Item No. **Report of the Head of Planning, Building Control, Sport & Green Spaces**

Address 734-736 UXBRIDGE ROAD HAYES

Development: Change of use of first and second floors from offices (Use Class B1) to a 10 bedroom House in Multiple Occupancy, involving installation of roof lanterns to first floor roof and installation of metal gates to side (Sui Generis)

LBH Ref Nos: **18920/APP/2015/2042**

sd00738/PL09
RFV B

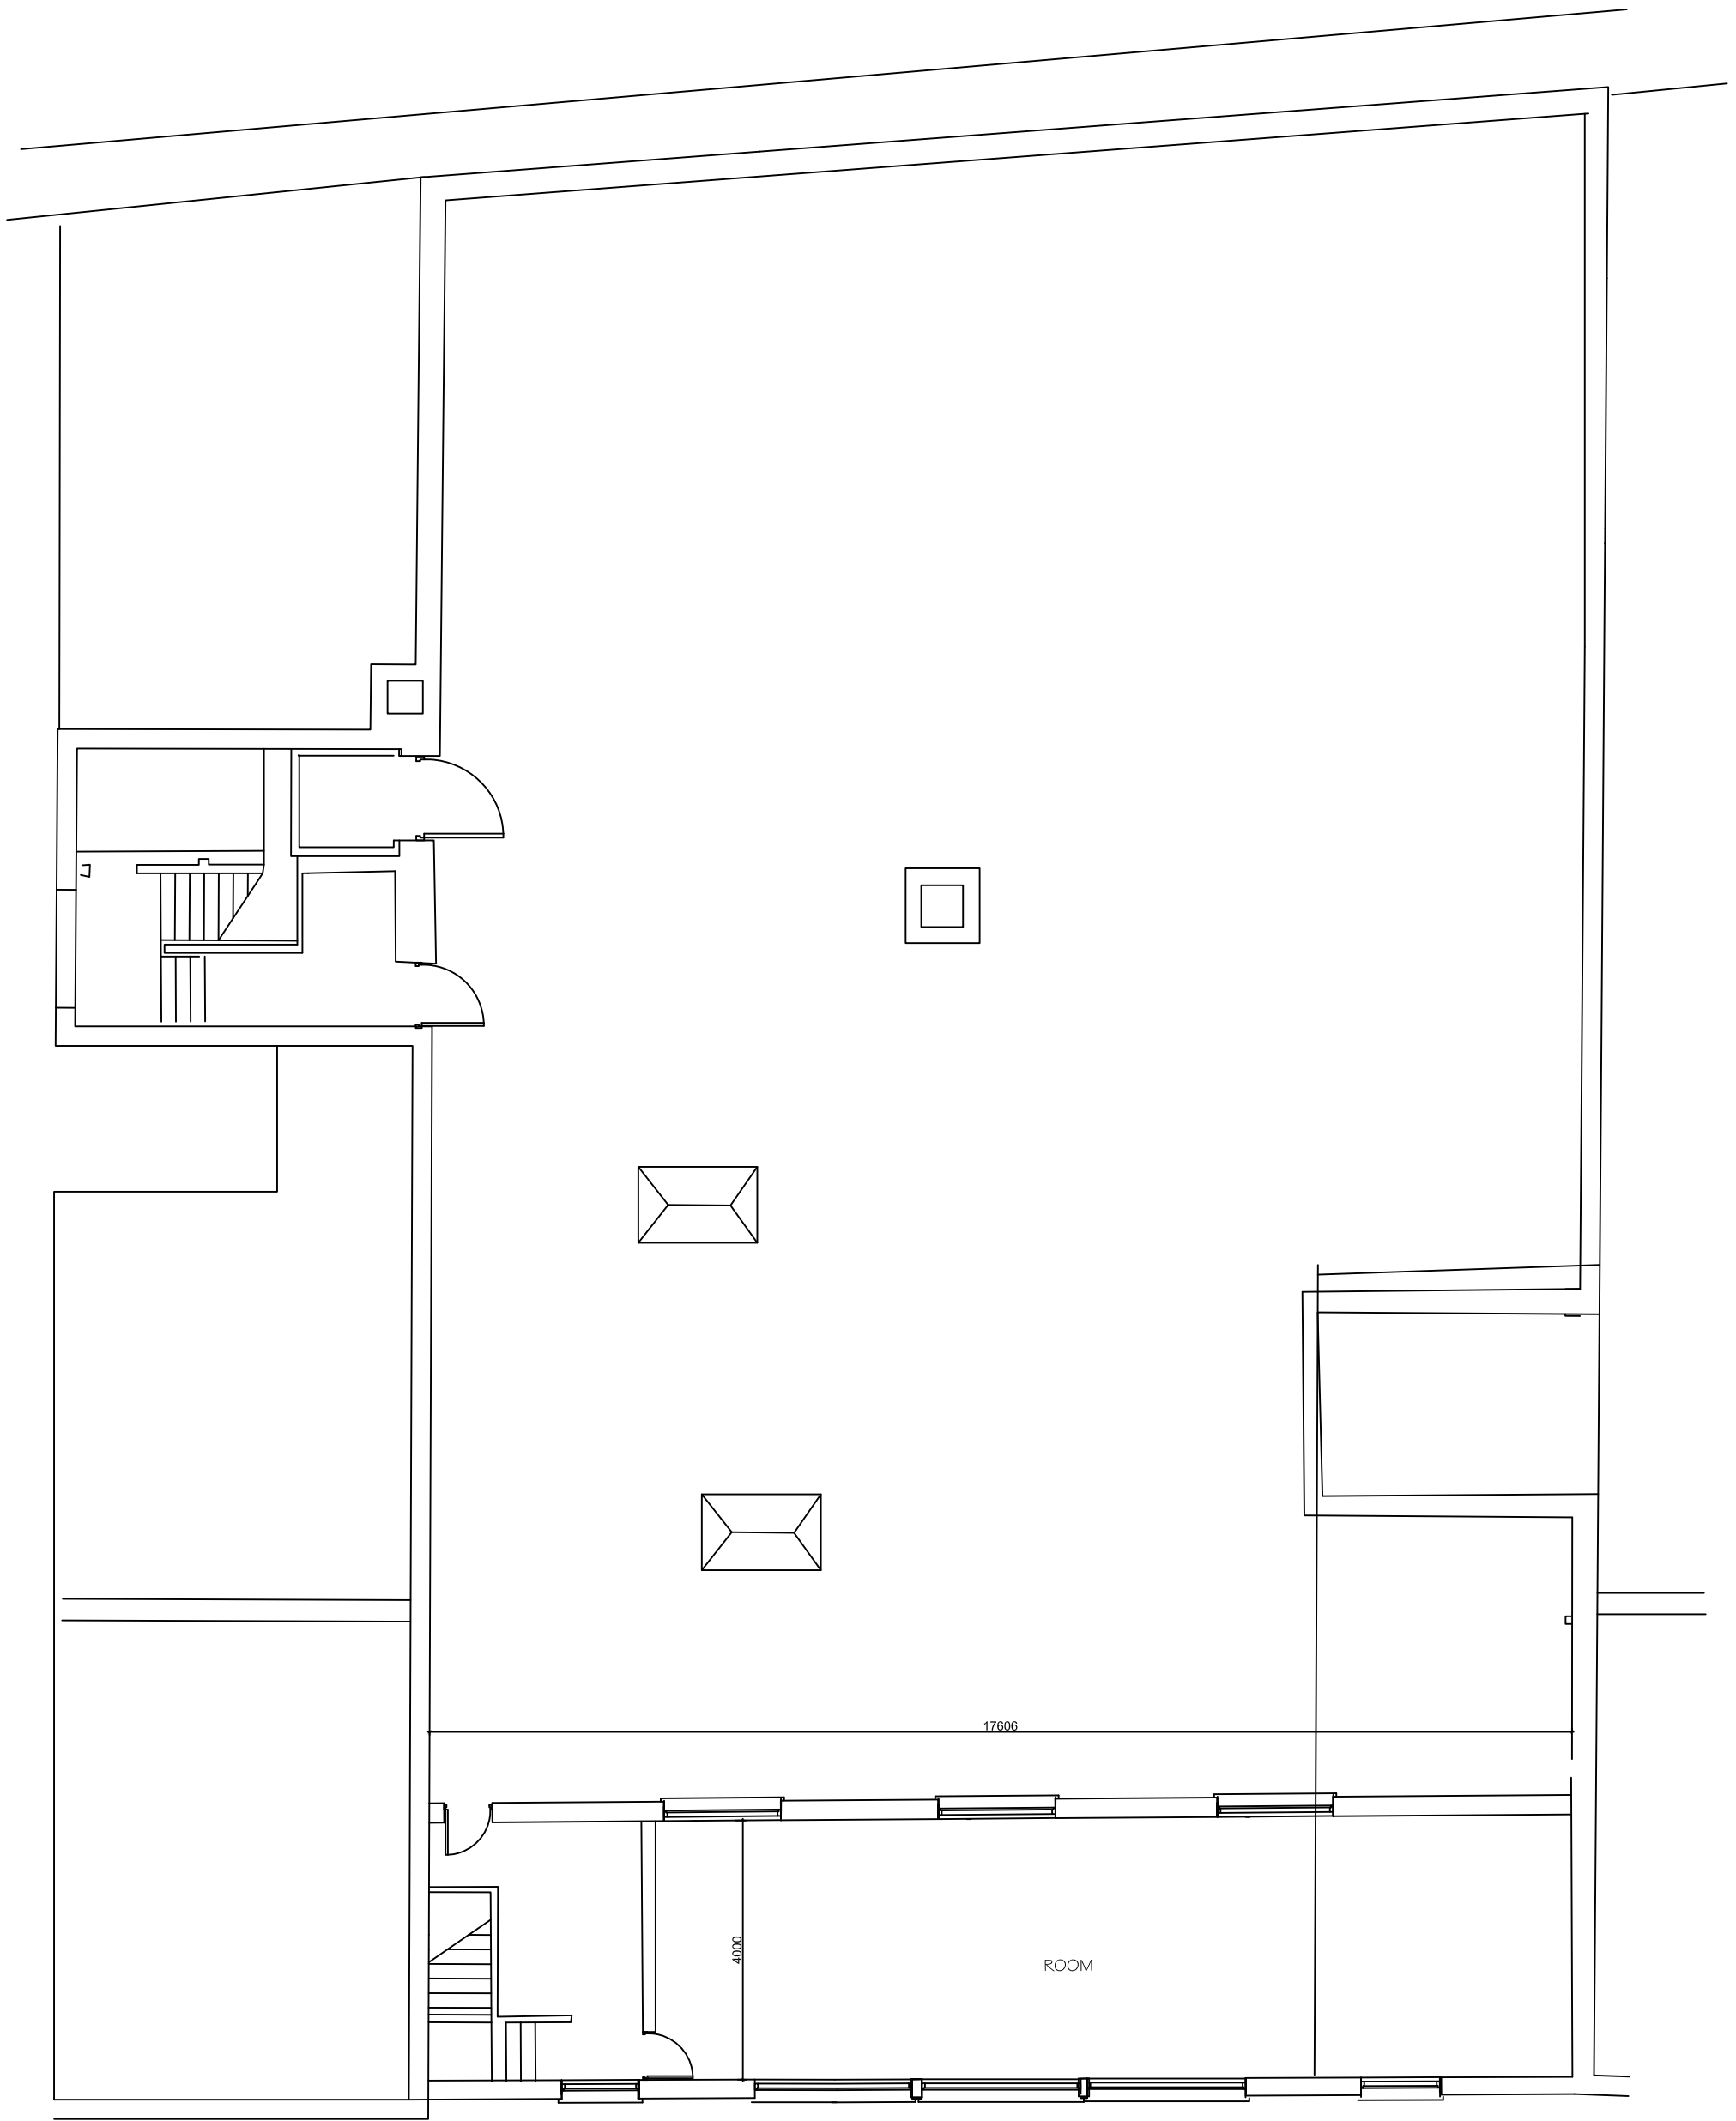
The applicant is advised that the second floor room remains unspecified in terms of its use which was raised as a concern by the Inspector in his recent appeal decision under reference APP/R5510/A/14/2228974.

kitchen which was identified as a key concern by the Inspector. Furthermore the use of the second floor room remains unspecified. Whilst the levels of daylight are considered, on balance, to be acceptable, the limited outlook to the communal areas remains unacceptable and as such the proposal would be contrary to Policies 3.5 and 5.3 of The London Plan 2011 and to Policies BE19 and BE20 of the Local Plan 2.

sd00738/PL08

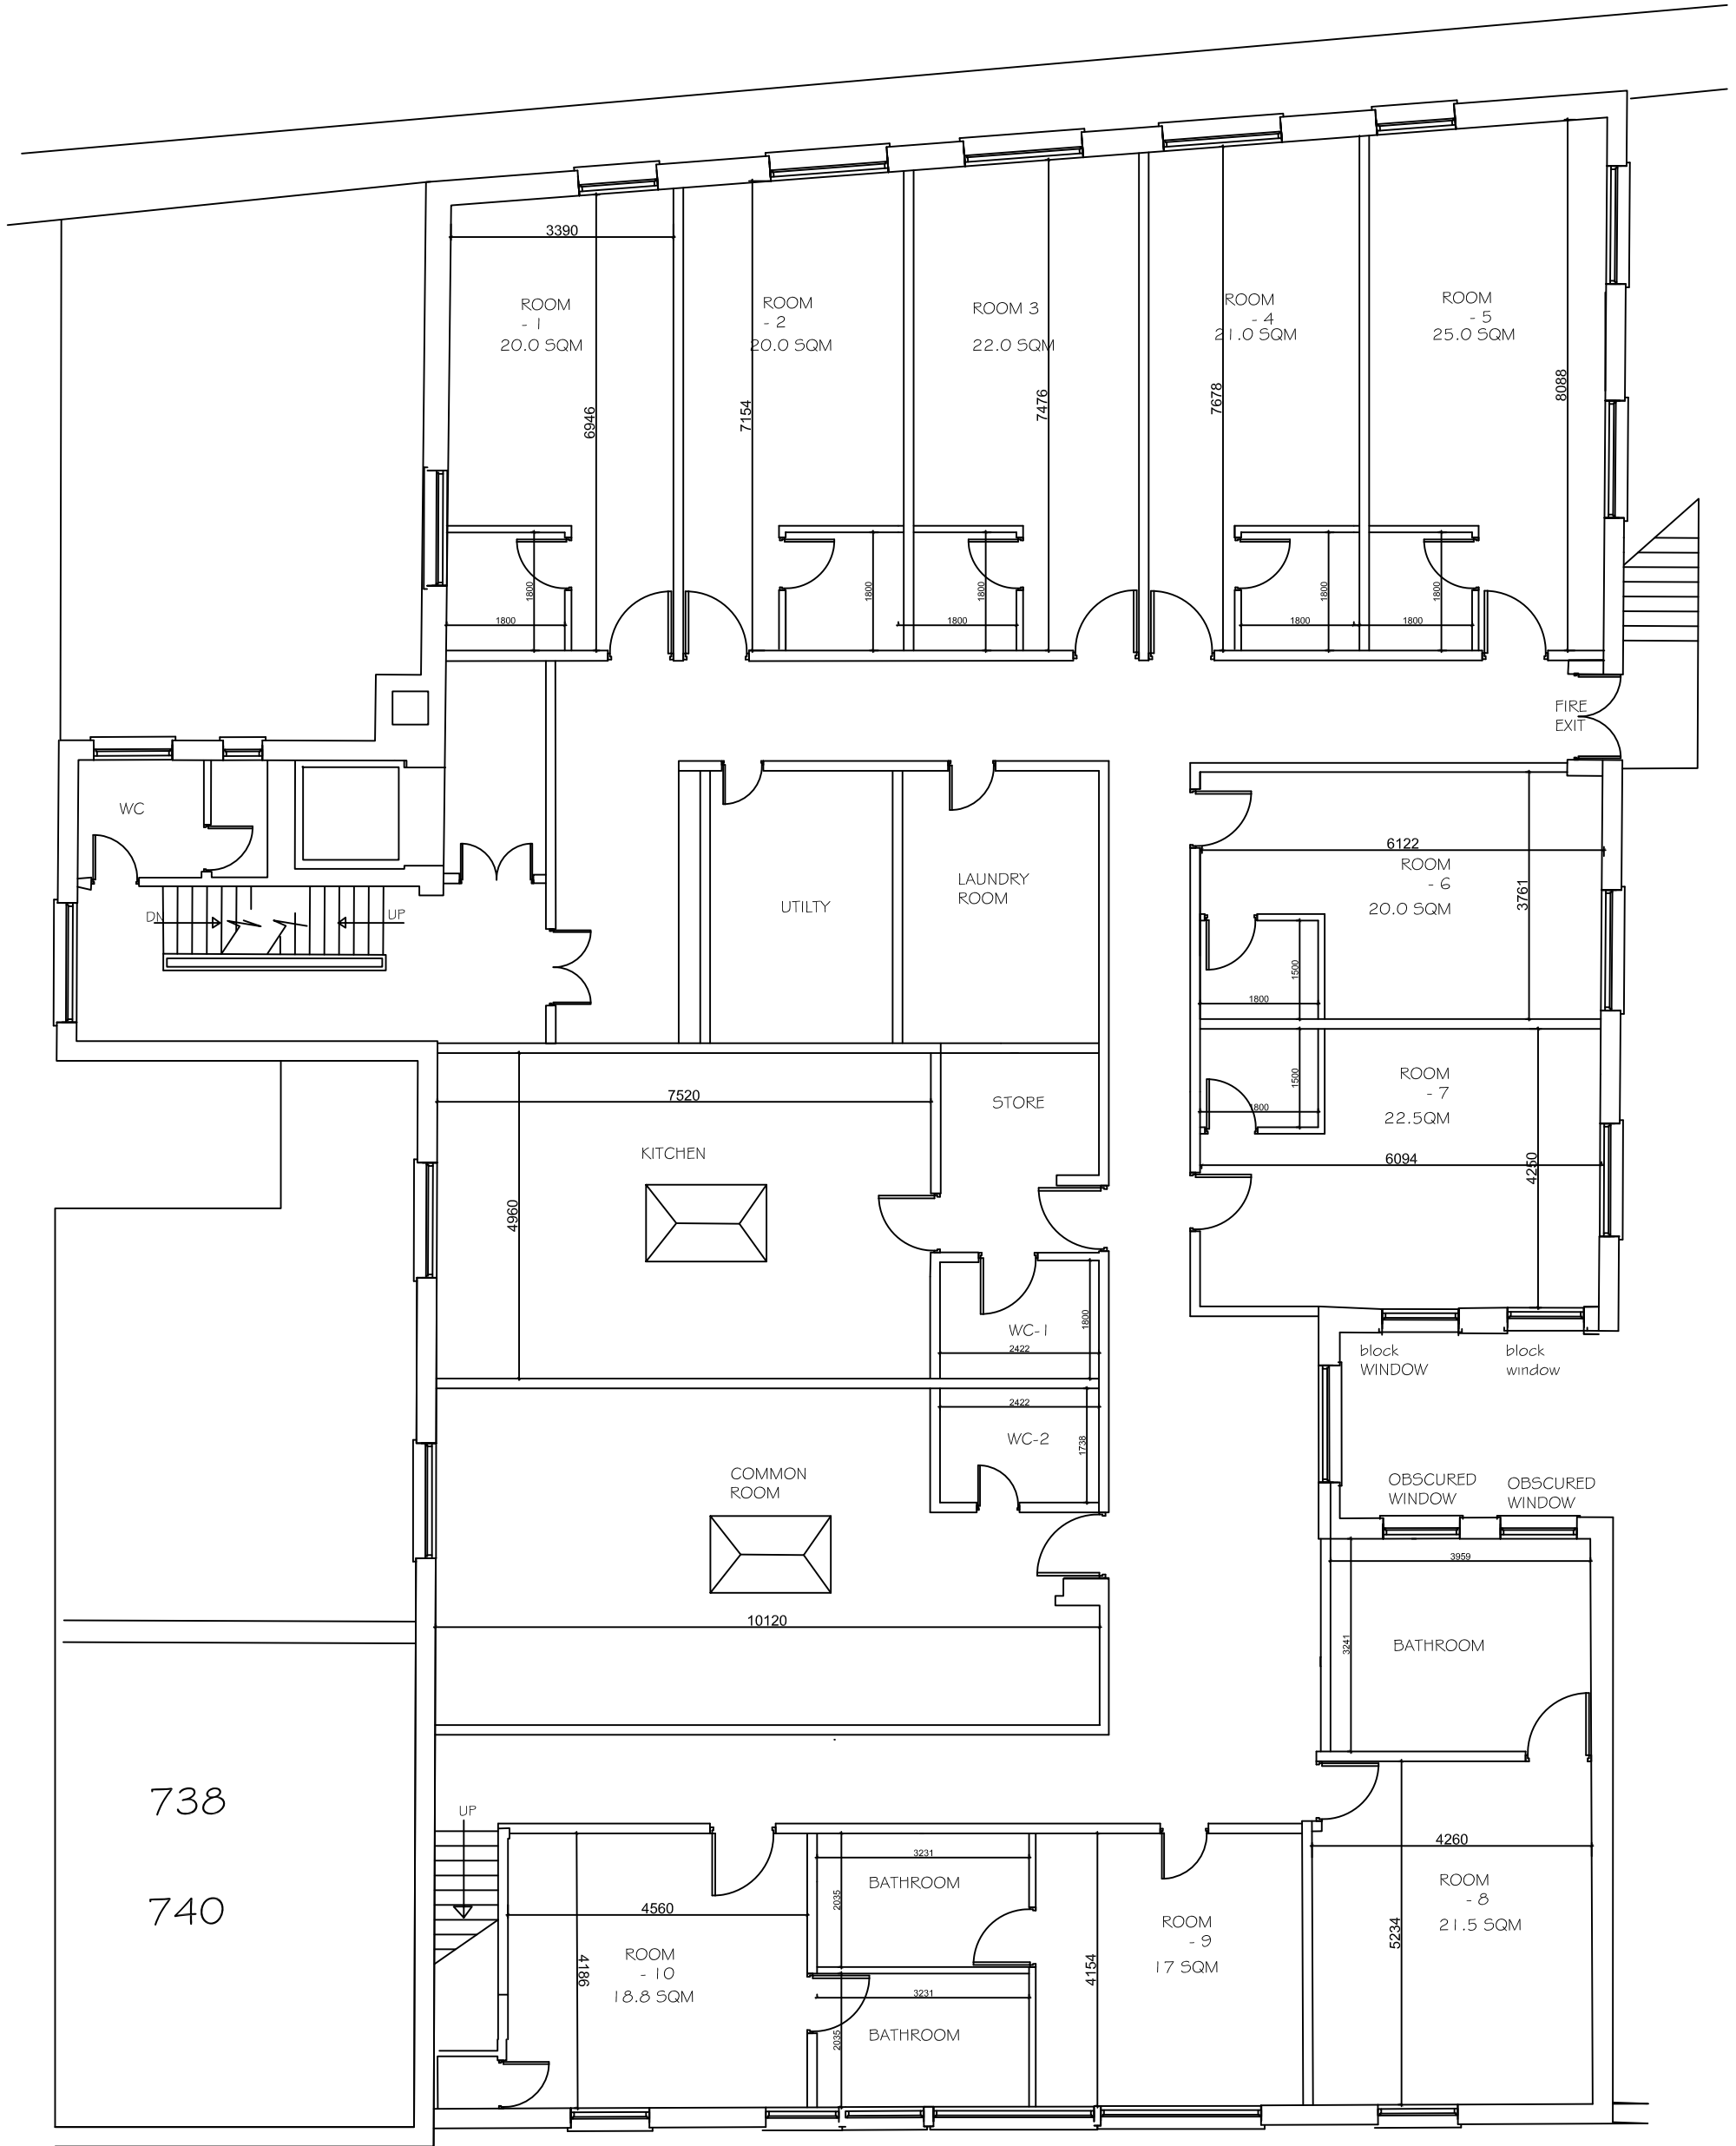
The outlook from the common room would be unsatisfactory having regard to the proximity of a large extractor flue serving nos. 738-740 next door and the rather unsightly flat roofed access to the adjacent residential units. Also, the submitted drawings fail to annotate any use accorded to the second floor accommodation, which is simply designated as "a room."

With regard to this revised application, the Council's Housing Officer has confirmed that no objection is raised to the level of daylight to the future occupants of the HMO. However, the revised plans fail to address the poor outlook to the common room and
